Reference No:	2026/62/90917/W
Site Address:	39, Spaines Road, Fartown, Huddersfield, HD2 2SD
Description:	Demolition of existing stone wall and formation of car parking space for electric car, and dropped kerb
Recommending Officer:	Joshua Merriman

DECISION - Refused

Officer Report – 2026/90917

03

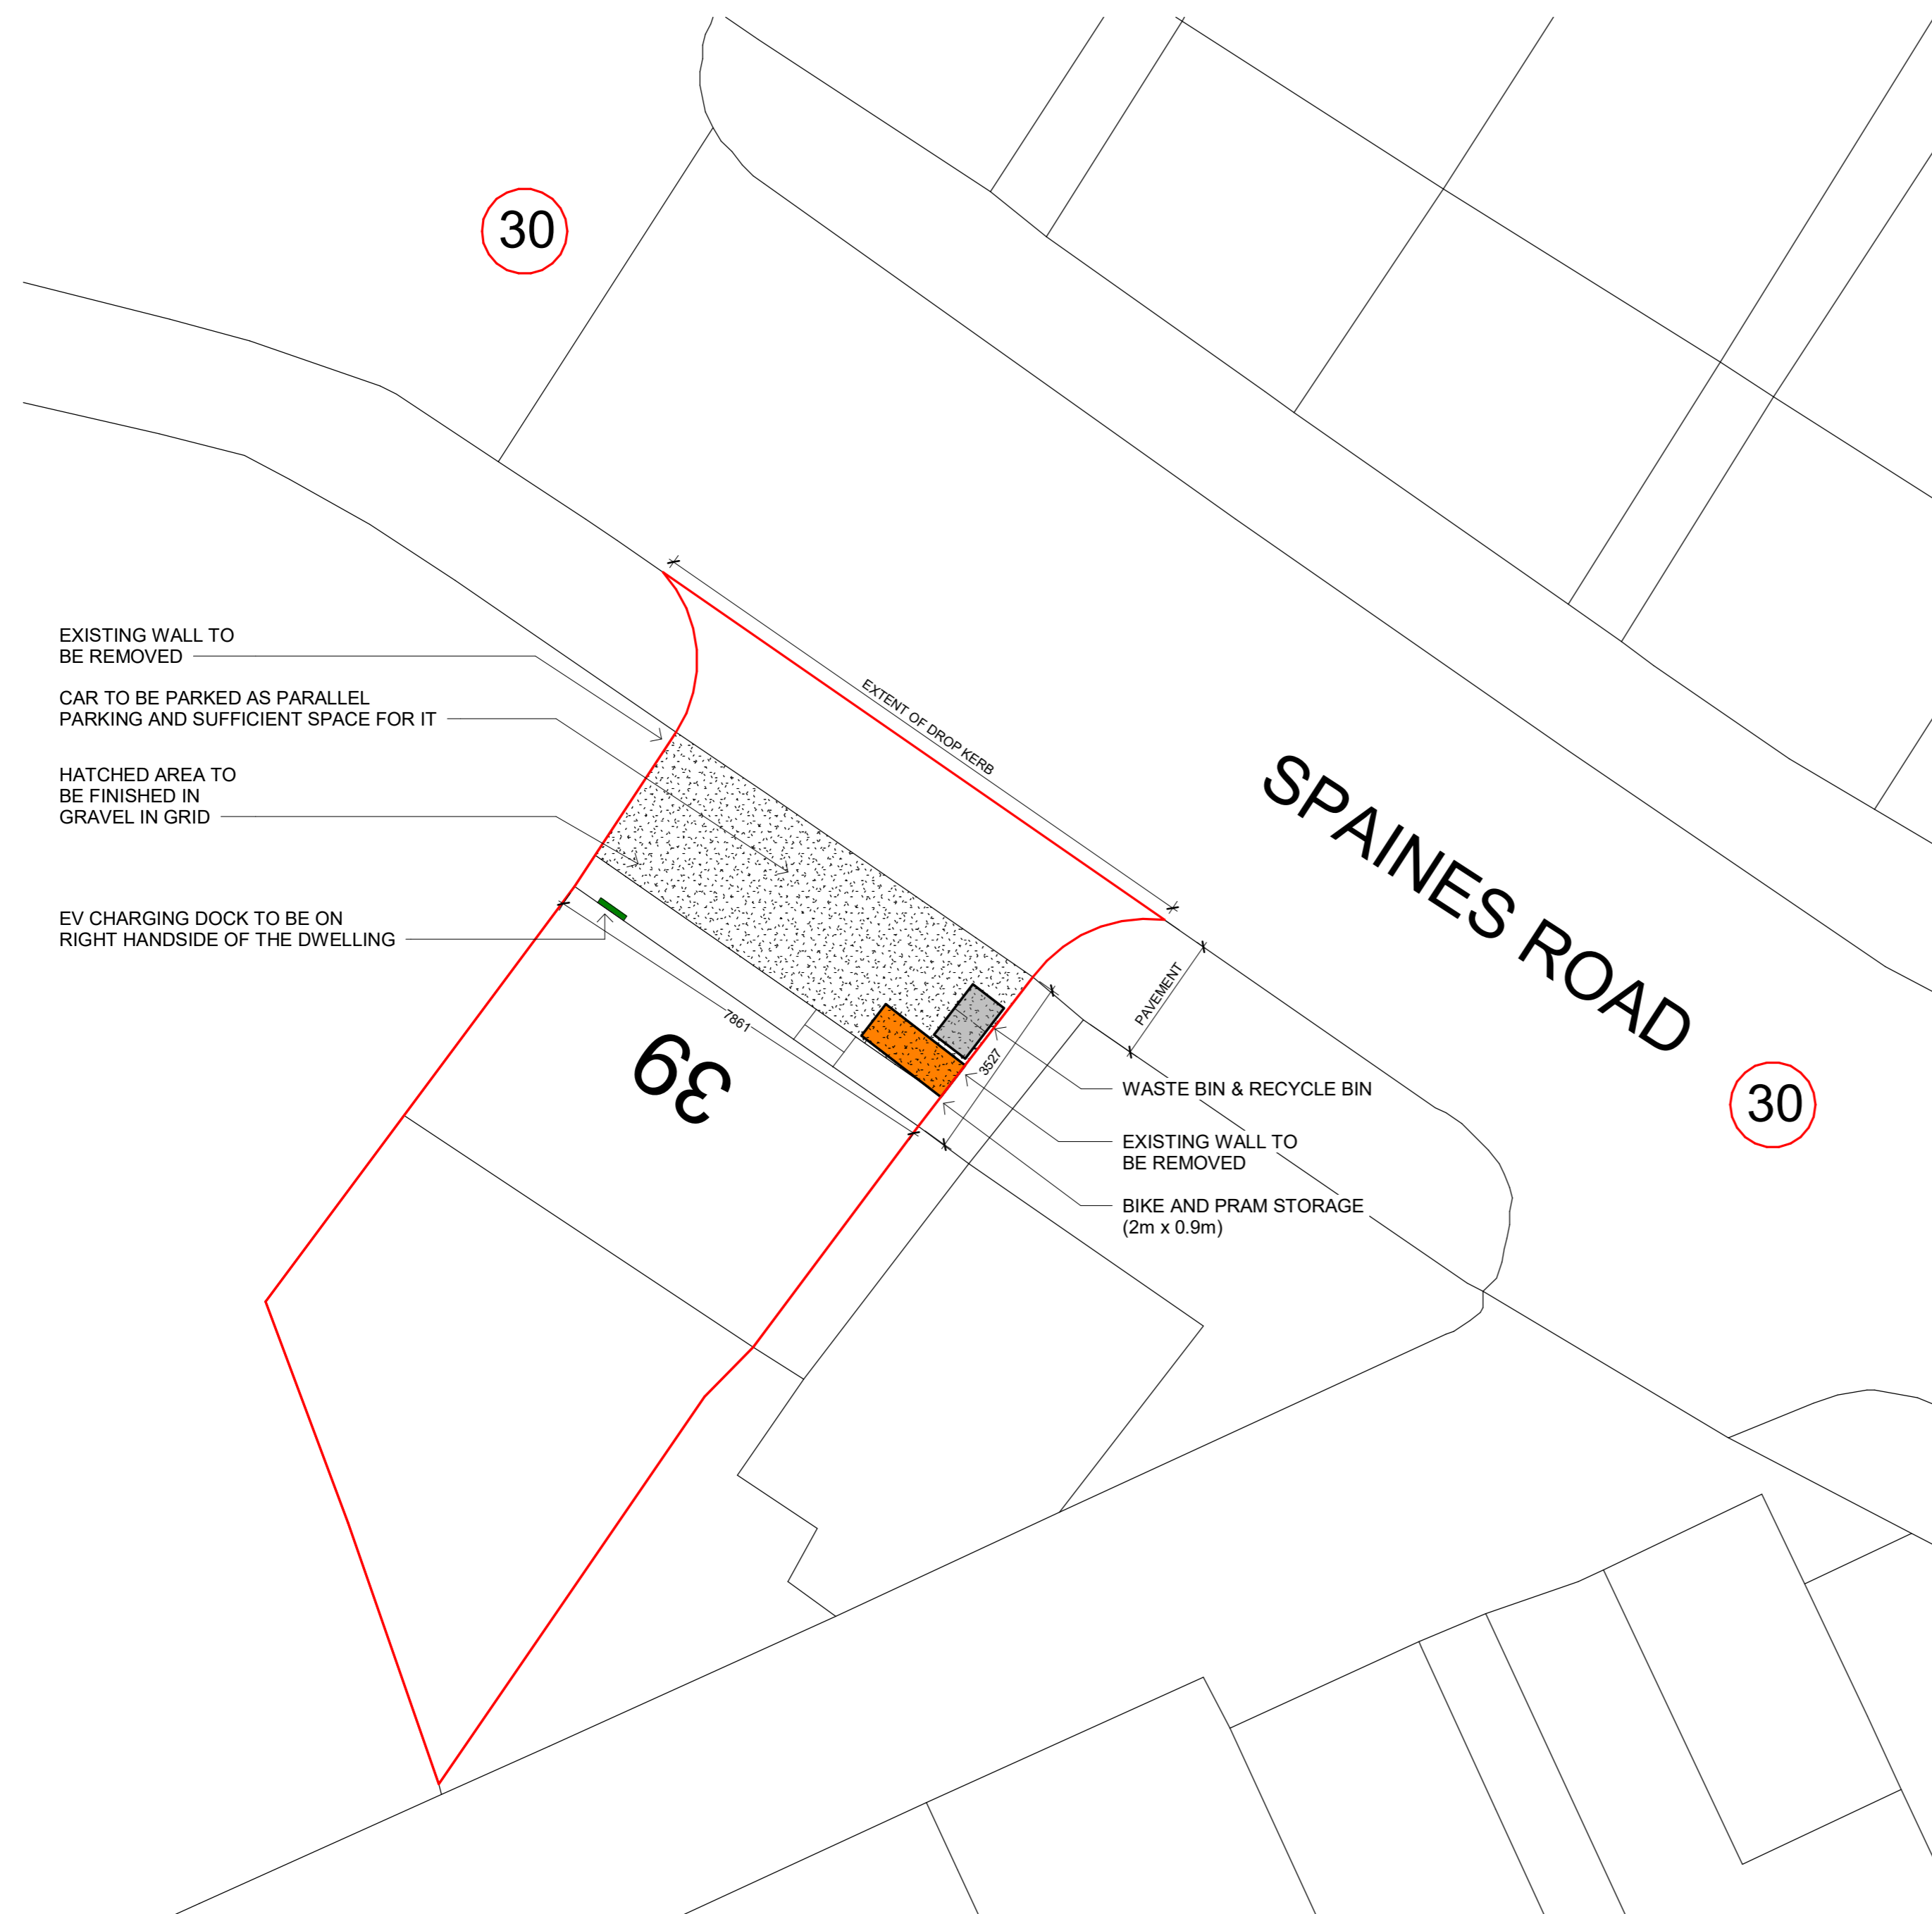
KC Highways Development Management - Sufficient space is not provided for safe manoeuvring in and out of the proposed parking space without an undue amount of use of the footway. There are also concerns that the visibility to the left exiting the space may be constricted and not to standards for a classified road, as such there is an objection to the proposals on highway safety grounds.

Given the comments aforementioned from KC Highways Development Management, there is an objection to the application on highway safety grounds. Considering this, the application cannot be supported.

1. The proposed development would result in an unacceptable impact upon highway safety, with the Local Highway Authority having raised concerns regarding sufficient space for maneuvering to and from the proposed parking space without undue use of the footway, as well as sufficient visibility splays when exiting the space. The proposal is therefore contrary to the aims of Policies LP21 and LP22 of the Kirklees Local Plan, Principle 15 of the Council's Street Design Guide and Chapter 9 of the National Planning Policy Framework.
